## Department of Planning and Environment

Our ref: Pymble Ladies College - Grey House Precinct - SSD-17424905

Subject: **Request for additional information- Pymble Ladies College - Grey House Precinct (SSD-17424905)**

Visual Privacy of adjoining context

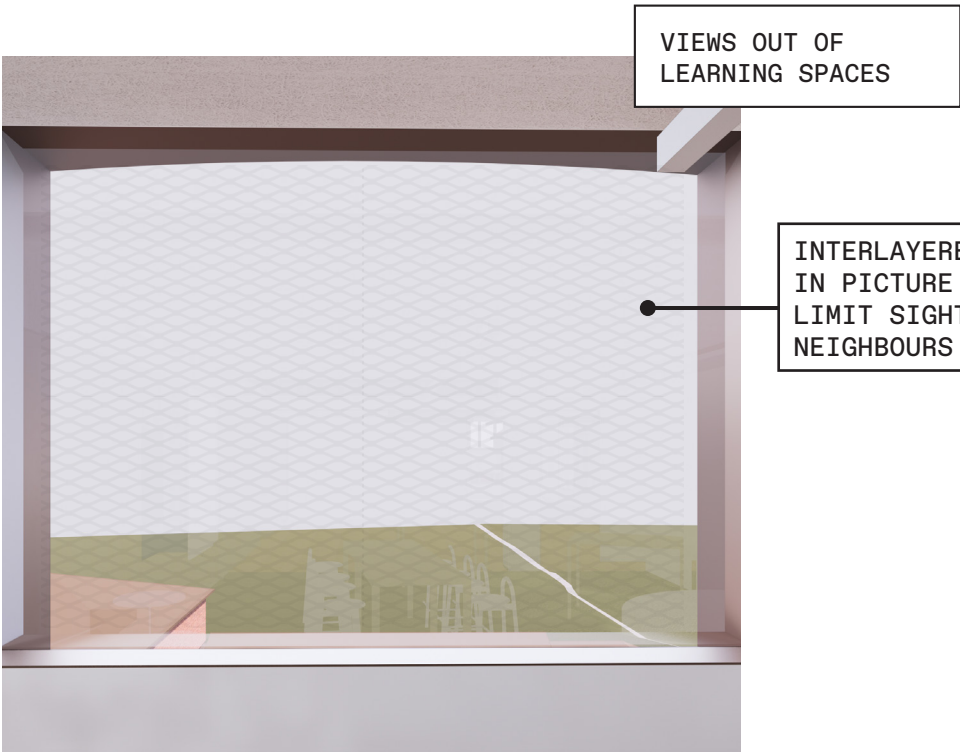
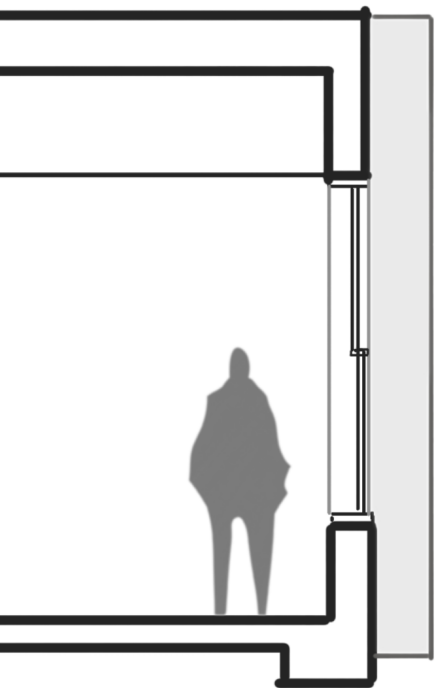
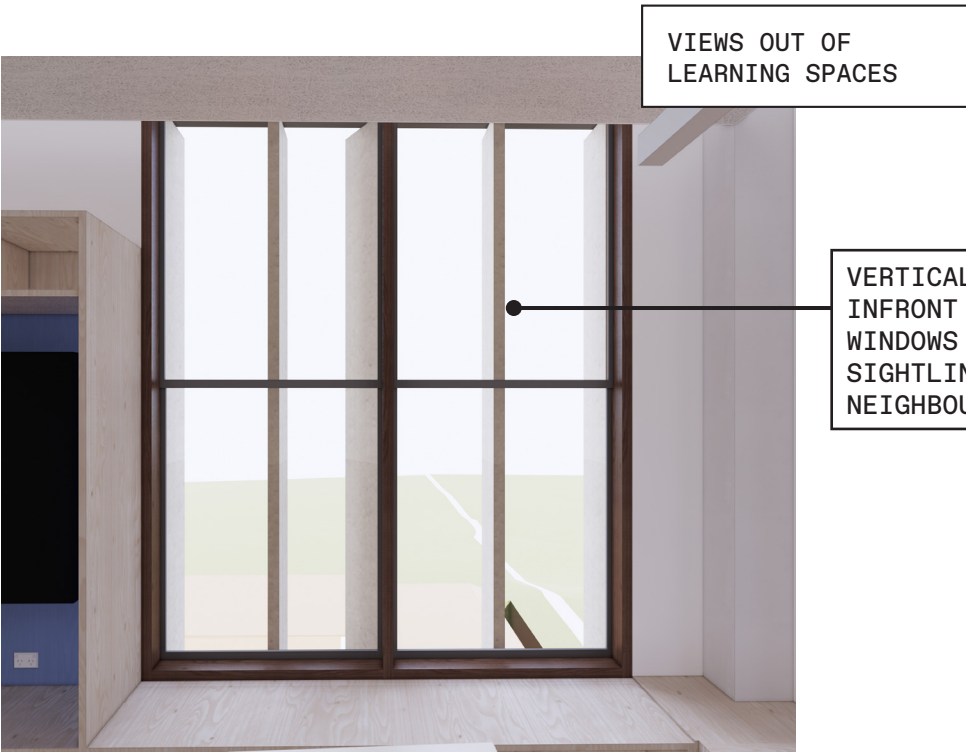
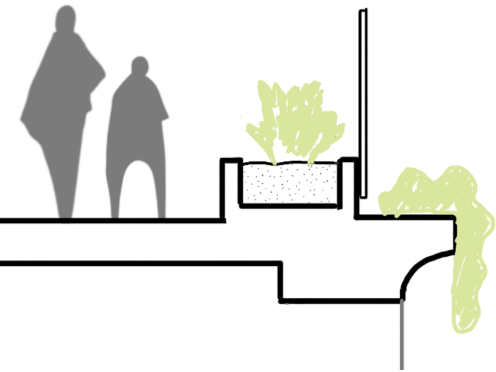
4. Please confirm whether the site area for the Grey House Precinct is 0.3ha or 0.06ha.
5. The Department notes the justification provided with regard to overlooking and visual privacy. However, the Department is concerned that the level 3 classroom windows and level 2 balcony of the proposed building may directly overlook on to the swimming pool and courtyards of the residential properties to the south (facing Pymble Avenue).

In this regard, the Department requires you to provide a more detailed view analysis diagram to demonstrate the extent of such overlooking (if any). Should the development result in adverse impacts on the privacy of the neighbouring properties, alternate solutions such as privacy glazing (obscure glass) or highlight windows should be explored and included in the design.

6. The submitted diagrams, showing the views from the site to 57 and 59B Pymble Avenue, do not show the location and/or boundary fence height. The diagrams should be amended to include a reference to the fence to clearly demonstrate the extent of overlooking.
